REQUEST

Current Zoning: N1-A (neighborhood 1-A), CG (general business)
Proposed Zoning: I-1(CD) (light industrial, conditional)

Approximately 3.55 acres bound by the east of side of Lakebrook Road, north side of Centergrove Lane, west side of Sam Wilson Road, and south side of Interstate 85.

The petition proposes to allow the development of convenience store with gas and diesel fuel pumps along with accessory and incidental uses associated with the principal use. The site is currently undeveloped.

SHEET TITLE:  
 REZONING PLAN  
 PETITION 2022-216

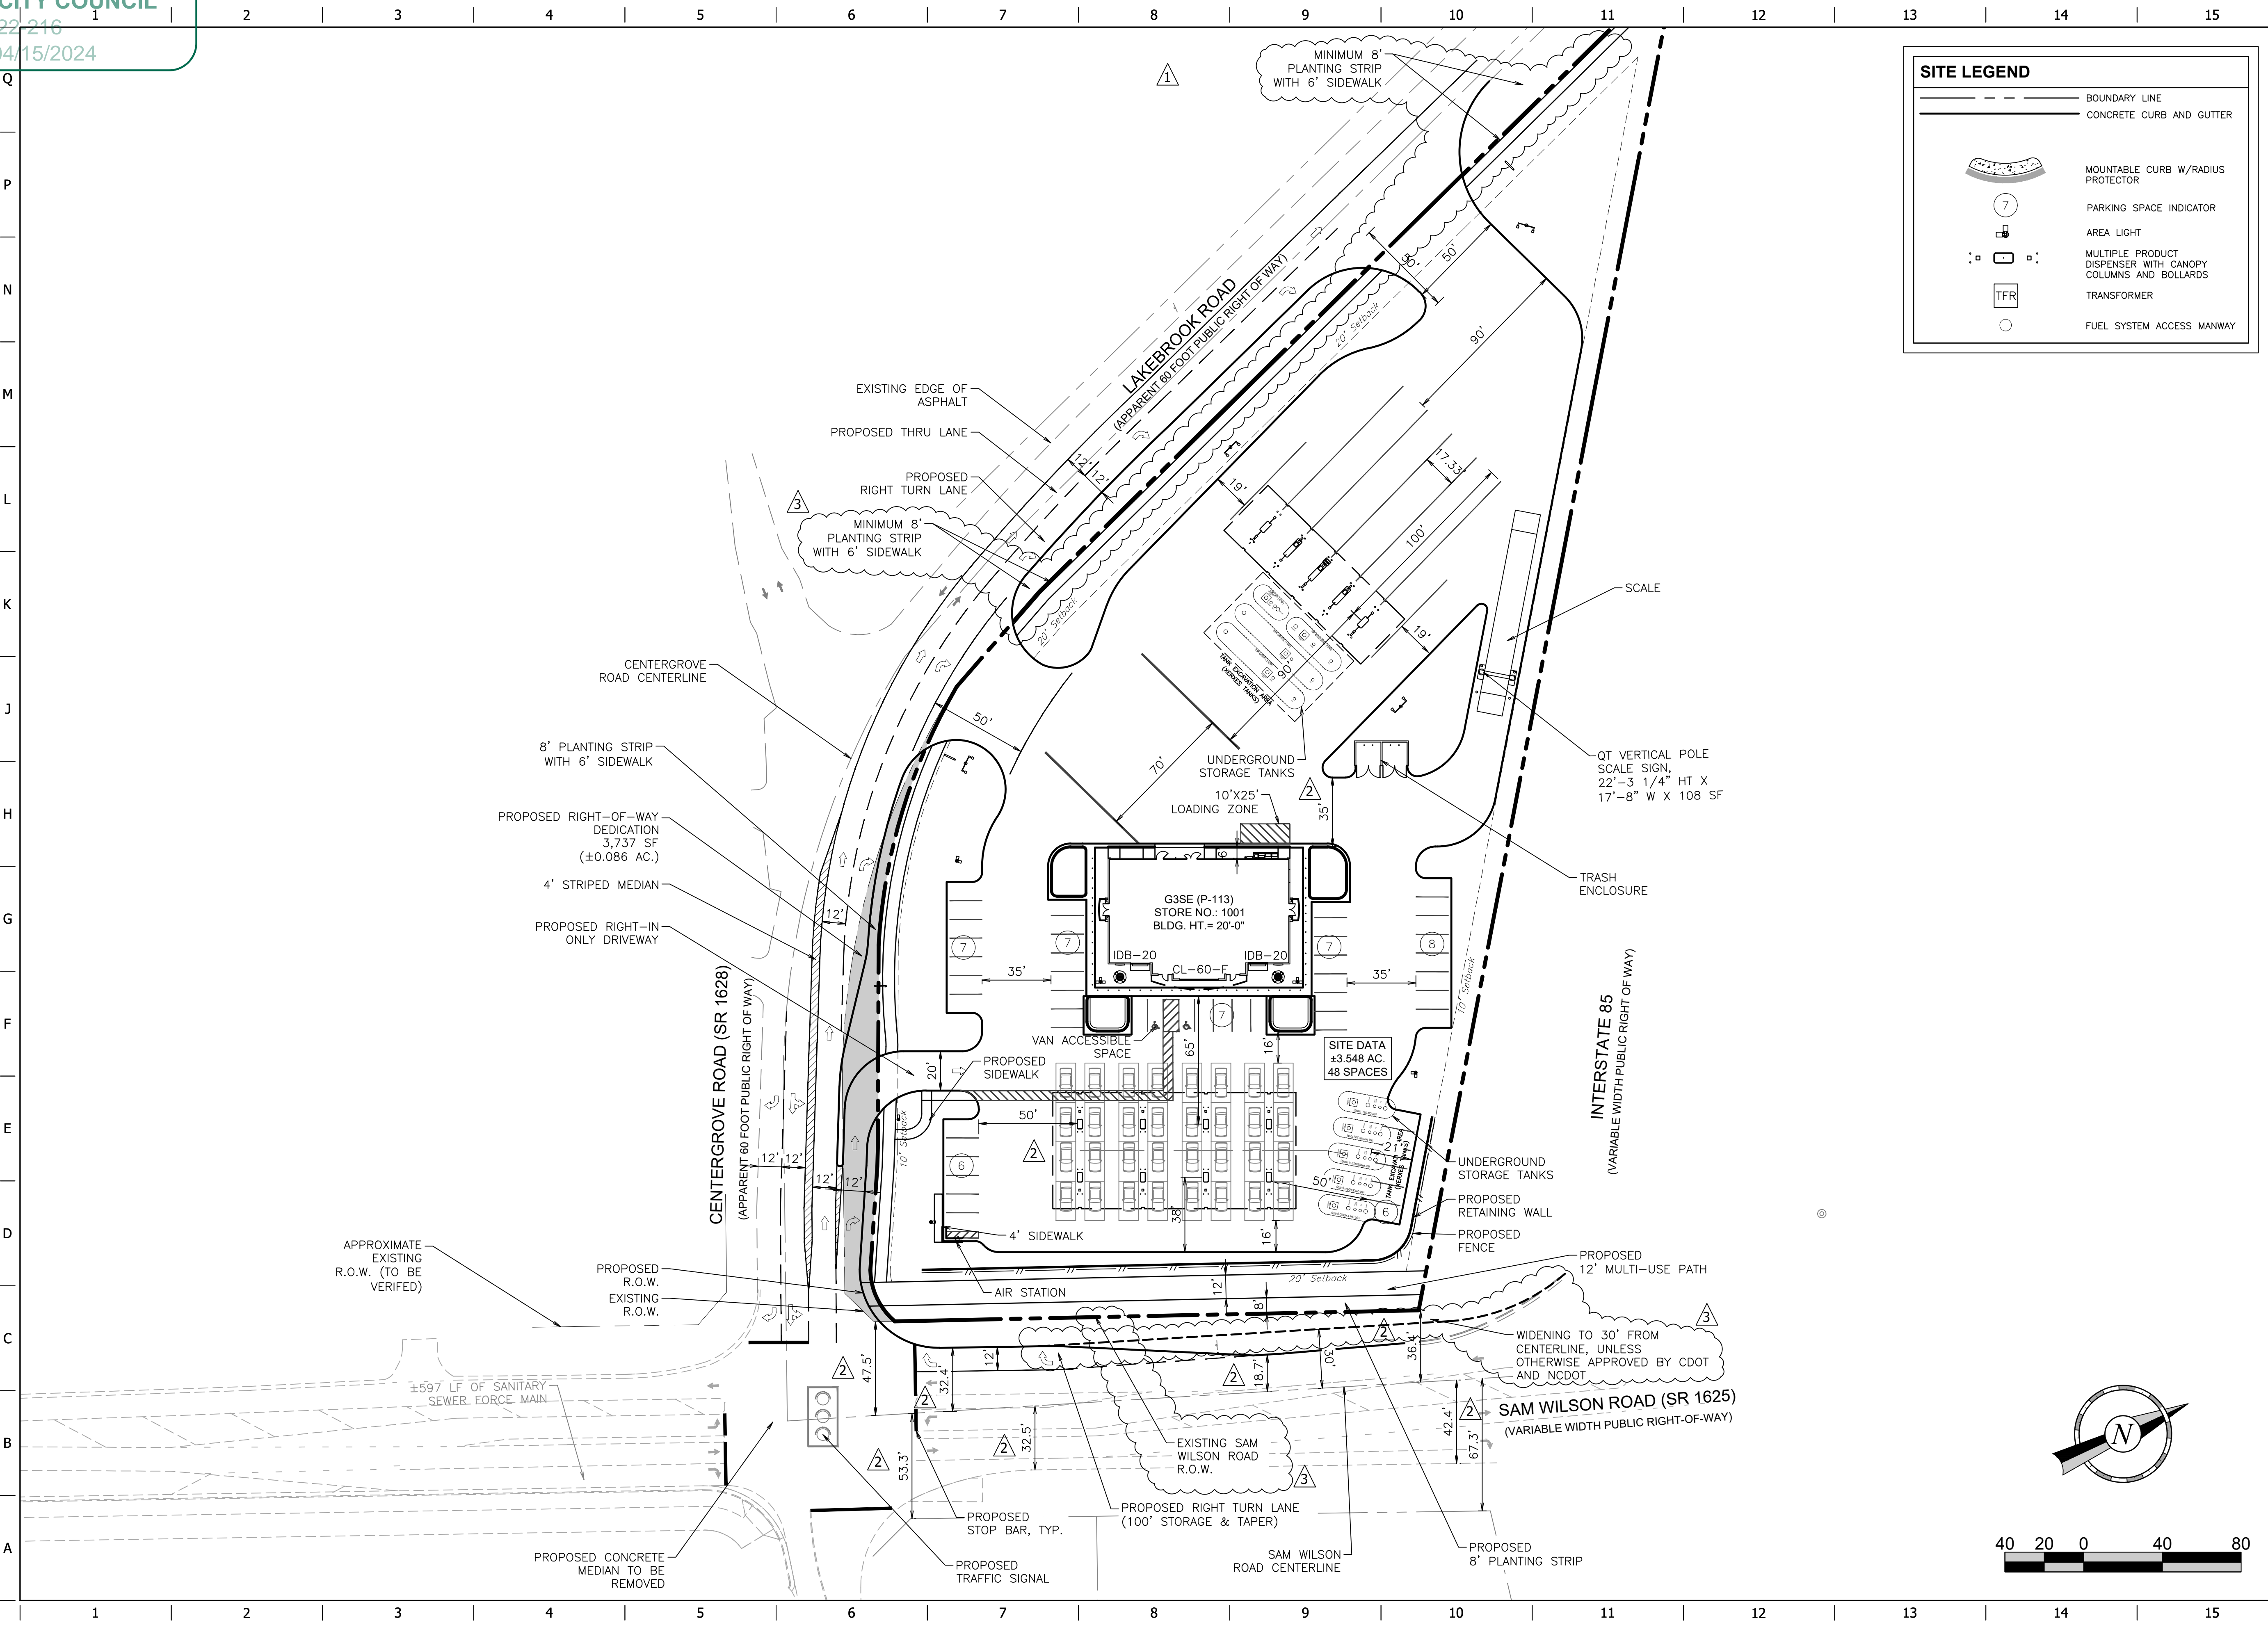
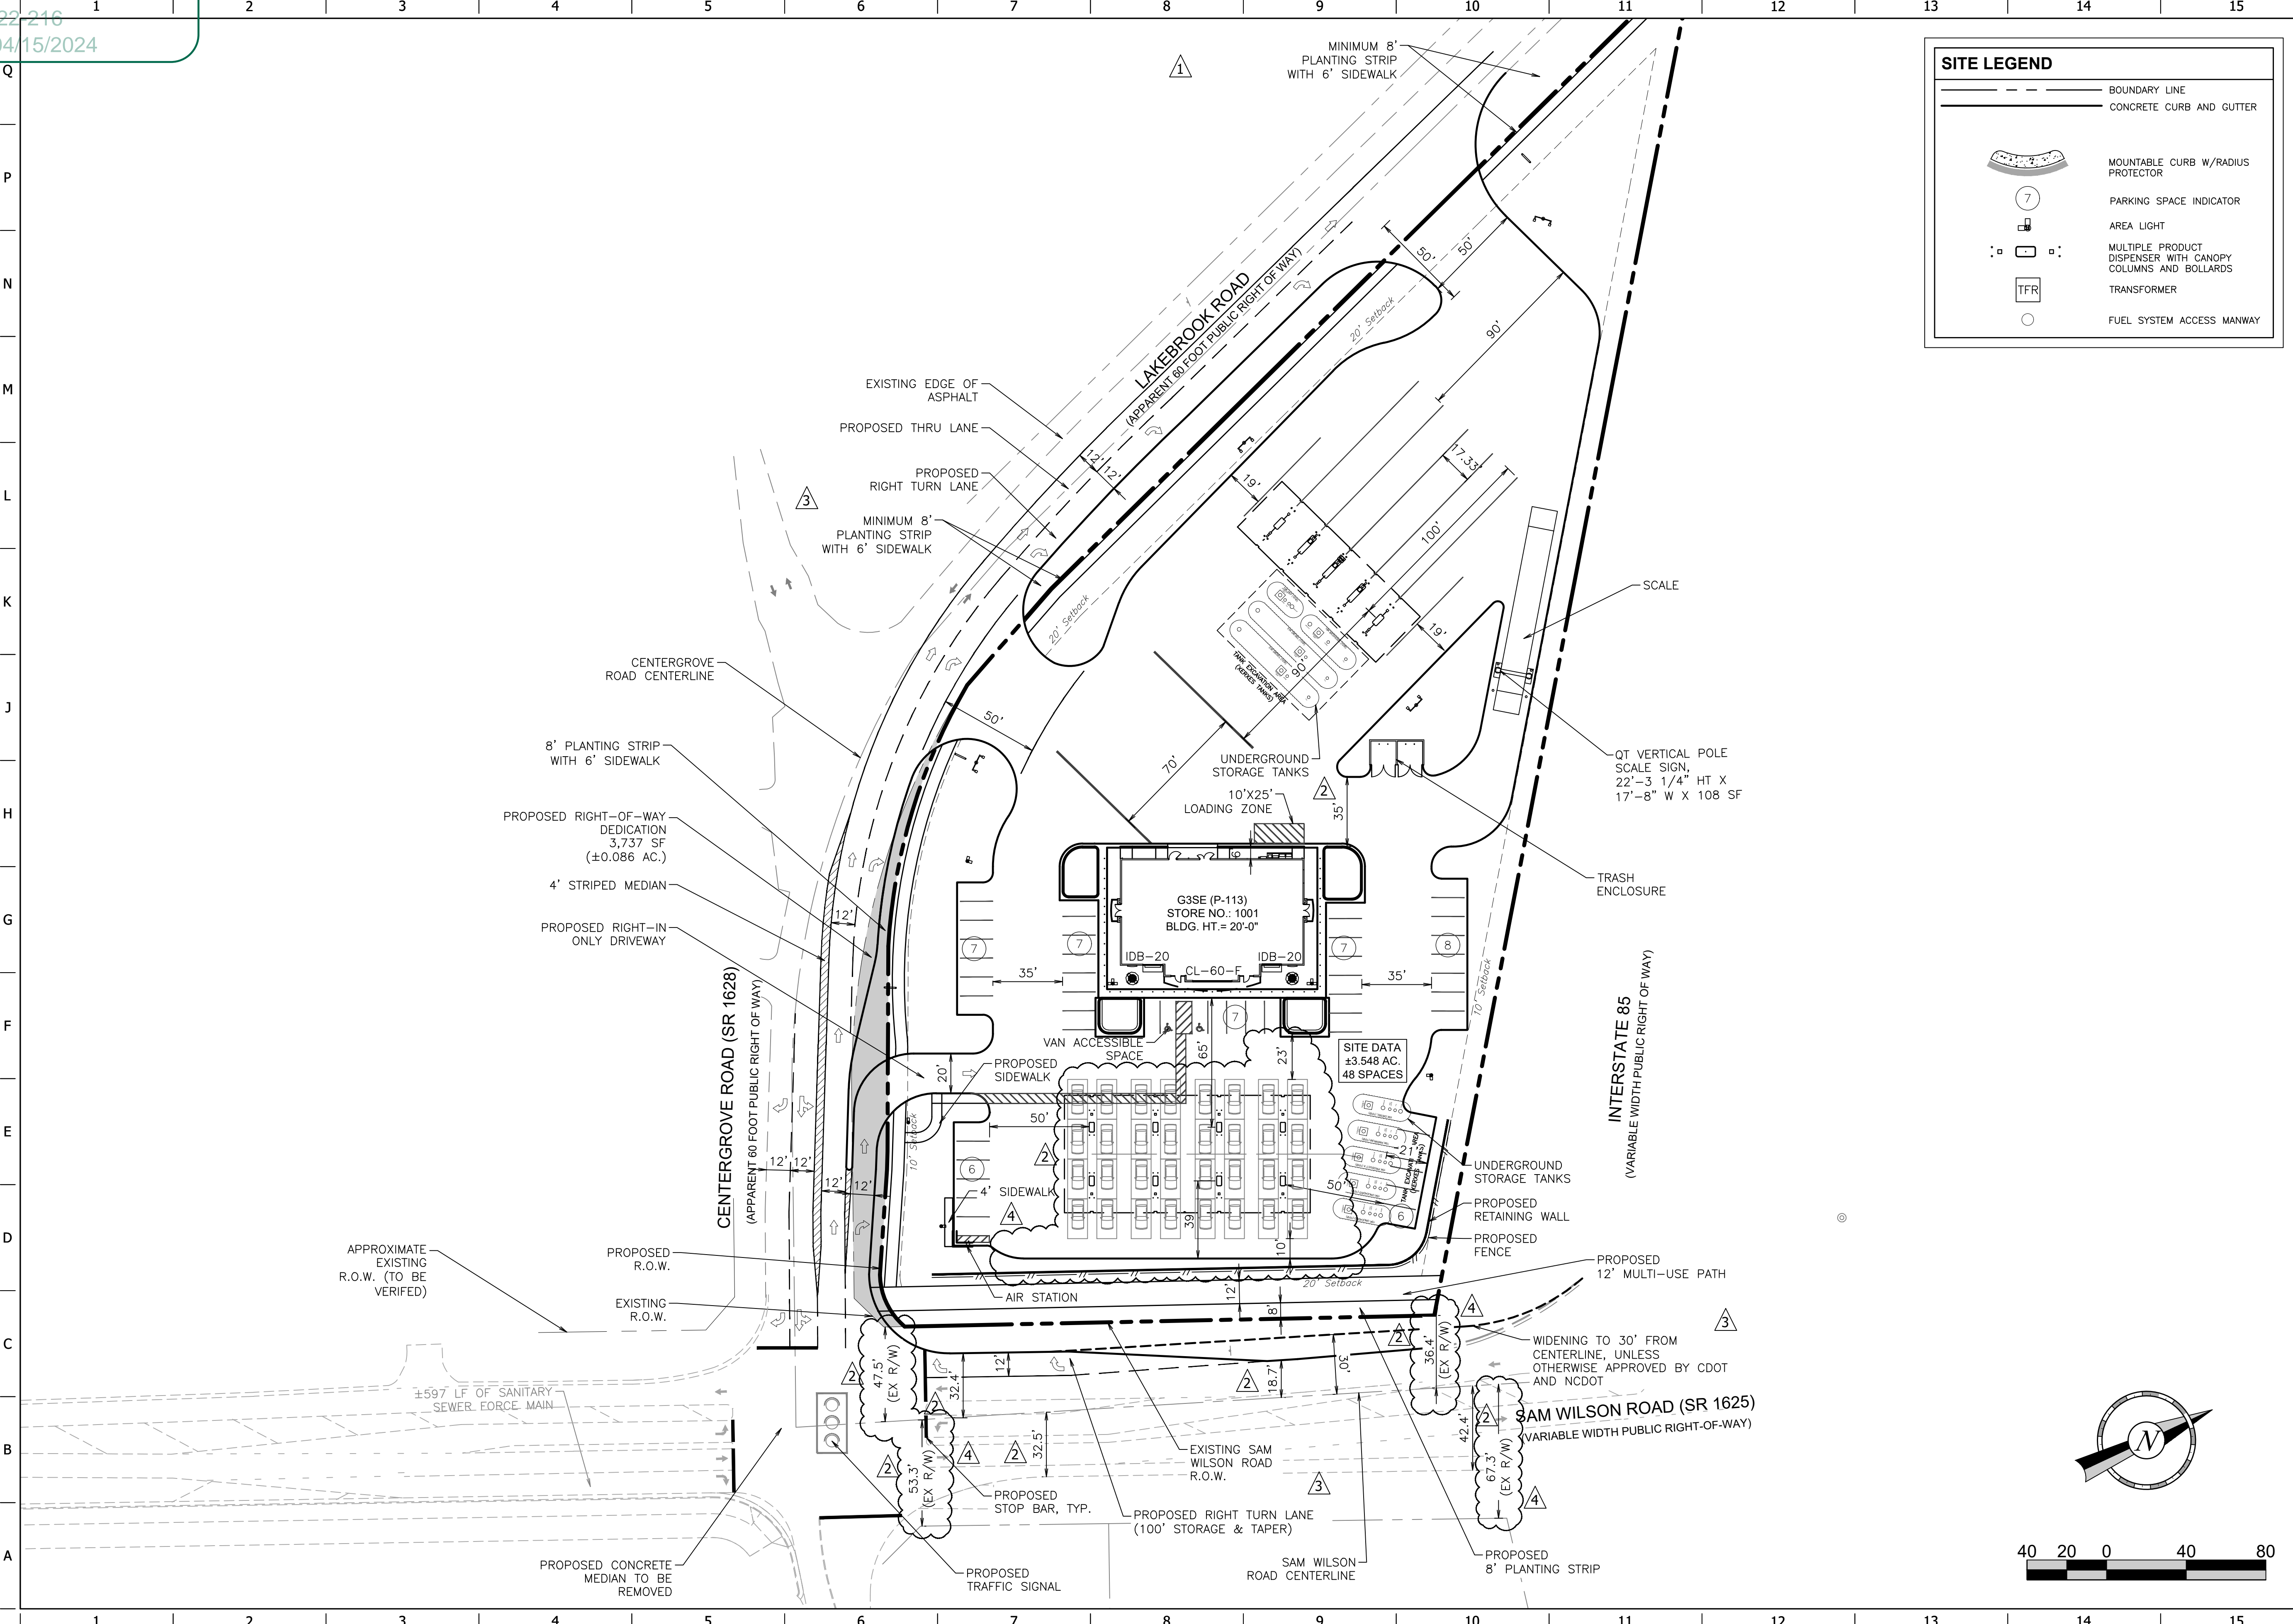
- ~~1. Location of curb and gutter to be moved to 30 feet from roadway centerline to accommodate the Charlotte Streets Map with a roadway typical section of a 4+ avenue with a 12-foot multi-use path. Label and dimension curb and gutter 30 feet from roadway centerline on Sam Wilson. **ADDRESSED**~~

- ~~2. Revise site plan and conditional note(s) to commit to dedicate 35 feet of right-of-way from the road centerline on Sam Wilson Road. The site plan shall label and dimension the right-of-way from the road centerline. Label and dimension right-of-way from roadway centerline on Sam Wilson. **ADDRESSED**~~

- ~~3. Revise site plan to clearly show and label where existing right of way is and proposed right of way. **ADDRESSED**~~
- ~~4. Revise site plan and conditional note(s) to construct 8-foot planting strips and 6-foot sidewalks on Centergrove Lane and Lakebrook Road and a 12-foot multi-use path on Sam Wilson Road. The site plan shall label and dimension both items from the back of curb and gutter or edge of pavement. Add conditional note The entire facility must be outside of the right of way and within a public access easement. Add conditional note committing to construction and maintenance of the 6-foot sidewalk on Centergrove Lane and the 12-foot multi-use path on Sam Wilson Road. Add conditional committing to maintenance of 6-foot sidewalk on Centergrove Lane. **ADDRESSED**~~
